**Re: Submission to Sydney Metro Environmental Impact Assessment**

# North Sydney Council

## **Submission to Sydney Metro City and Southwest Environmental Impact Statement**

27 June 2016

Fig 1: Central Laneways Precinct and Metro Location

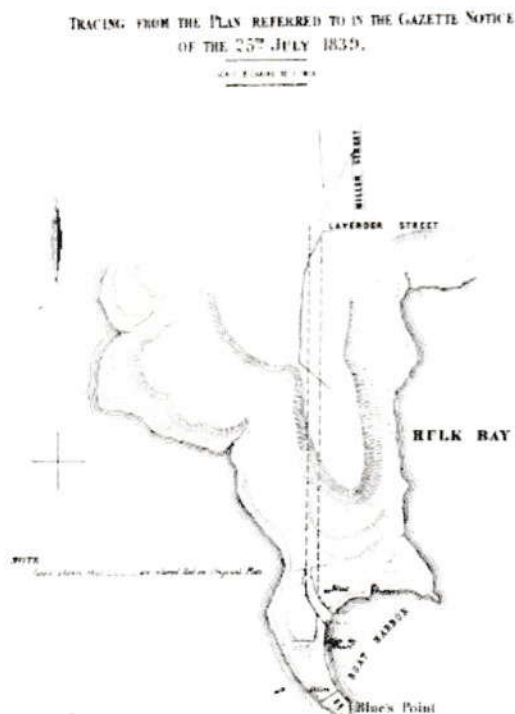
Denison Street therefore requires significant design consideration and intervention to contribute to the operation of the Metro. Council has identified opportunities to improve the safety and amenity of Denison Street via an as-yet unendorsed masterplan for the adjoining laneways network. The Central Laneways Masterplan intends to guide future detailed design for the station and its eastern interface, and identifies opportunities to:

- Pedestrianise the southern portion of Denison Street;
- Create a new unique urban precinct within the North Sydney CBD;
- Revisit existing development approvals to better align with proposed Metro outcomes; and
- Improve pedestrian amenity and connectivity between the Metro and other destinations within the North Sydney CBD.

Work with Council to design and implement measures to ensure that Denison Street and the laneway network integrates successfully with Metro operations.
